**RFI**

RFI #: 187  
 Date: 9/4/2012  
 Job: EB-02 Keller Springs Lofts  
 Phone: 877-777-5115

Subject: Parapet walls supports

2 DIVISION 'B' WEST ELEVATION NFI 210

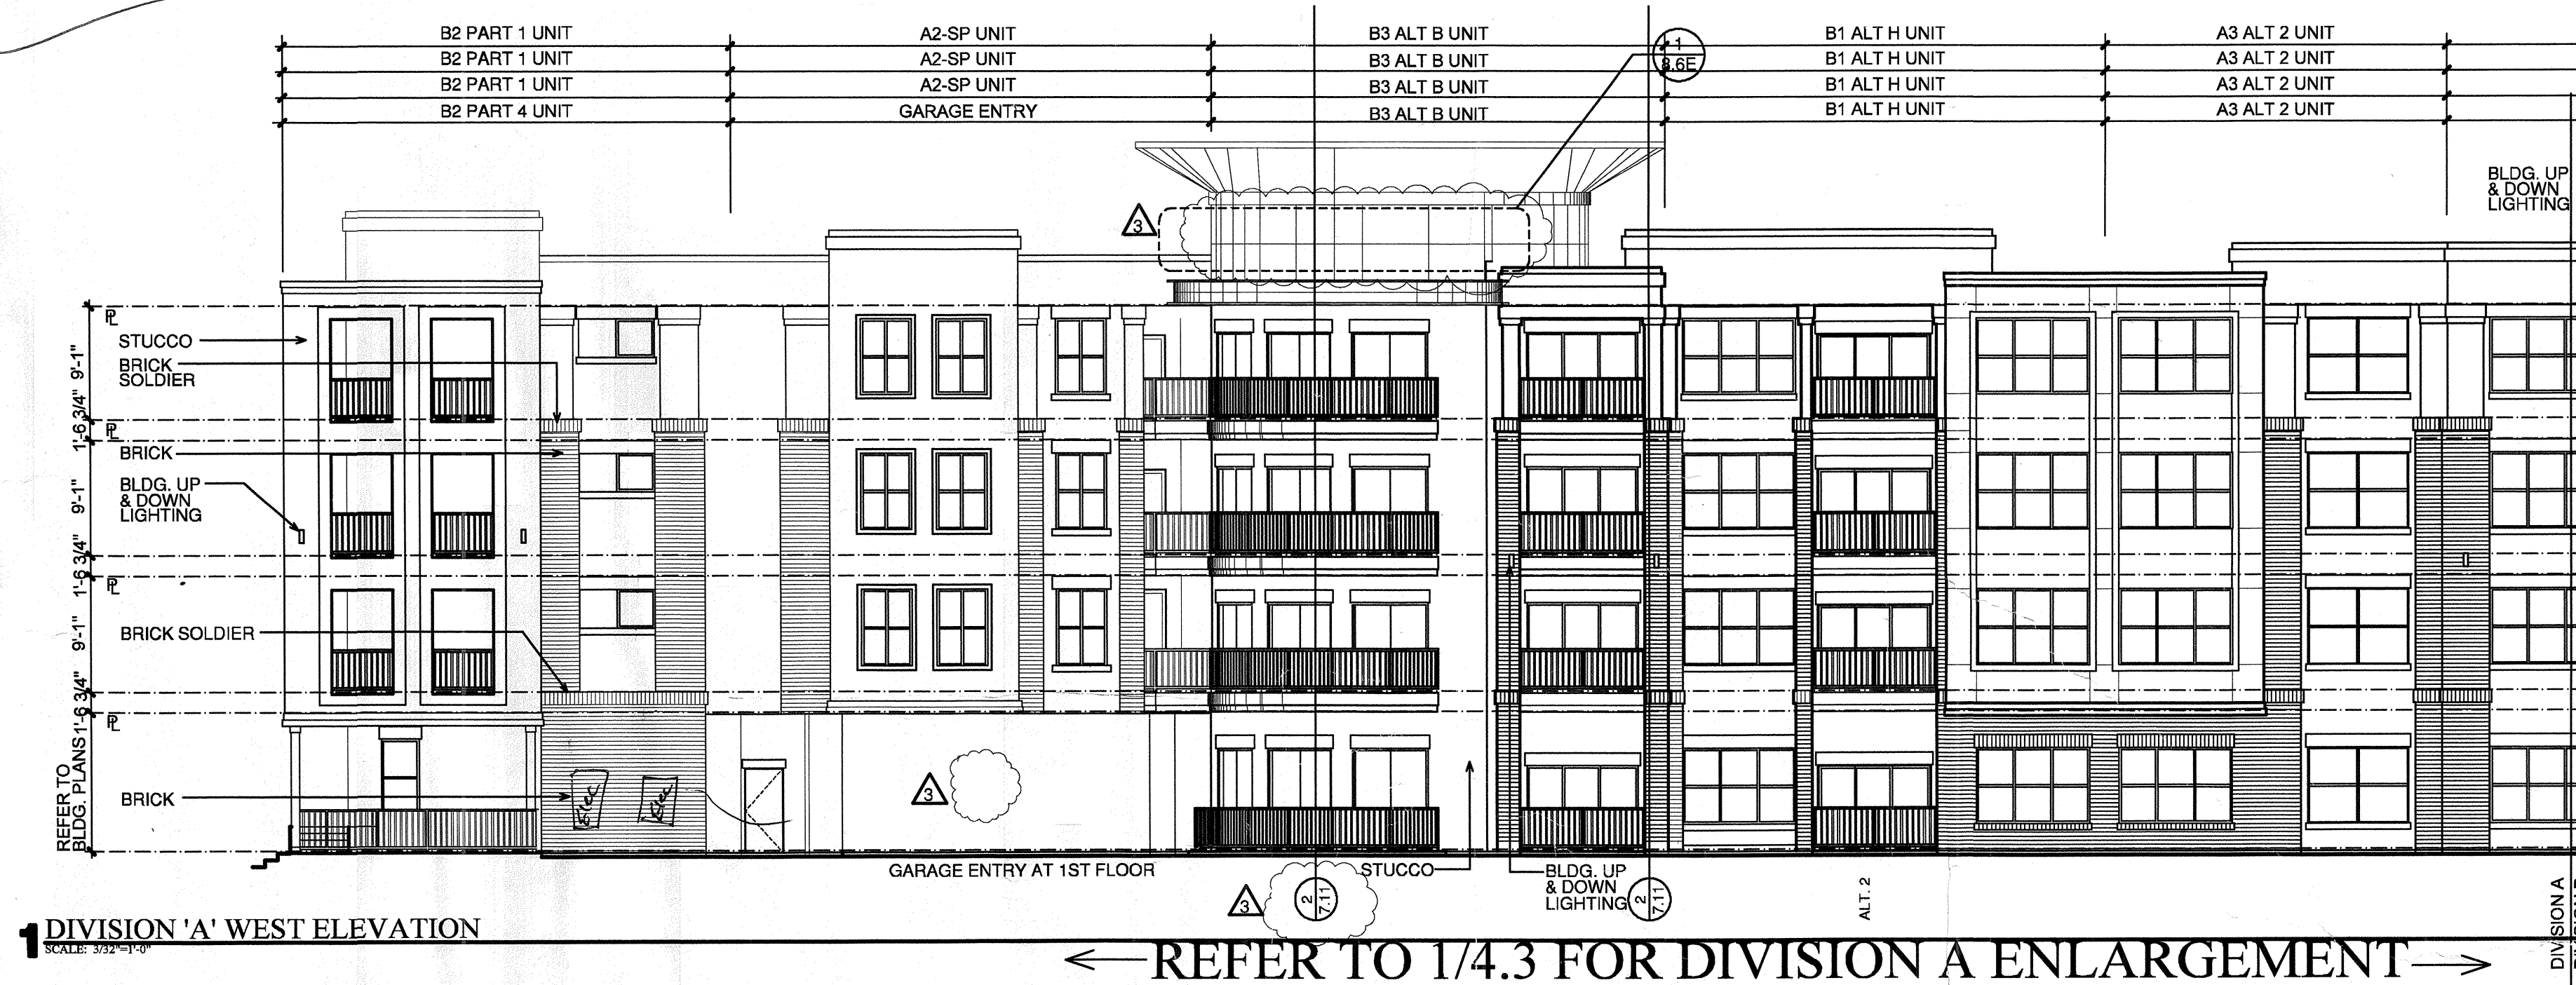
Request: We have parapet walls that are 10' tall, an example of this is 1SS.02 and 2/4.3 is there a minimum height that we should install additional support that ties back into the roof system for wind load? If so please provide the height and a drawing showing us how to structurally tie them in.

Please see attached sketches.
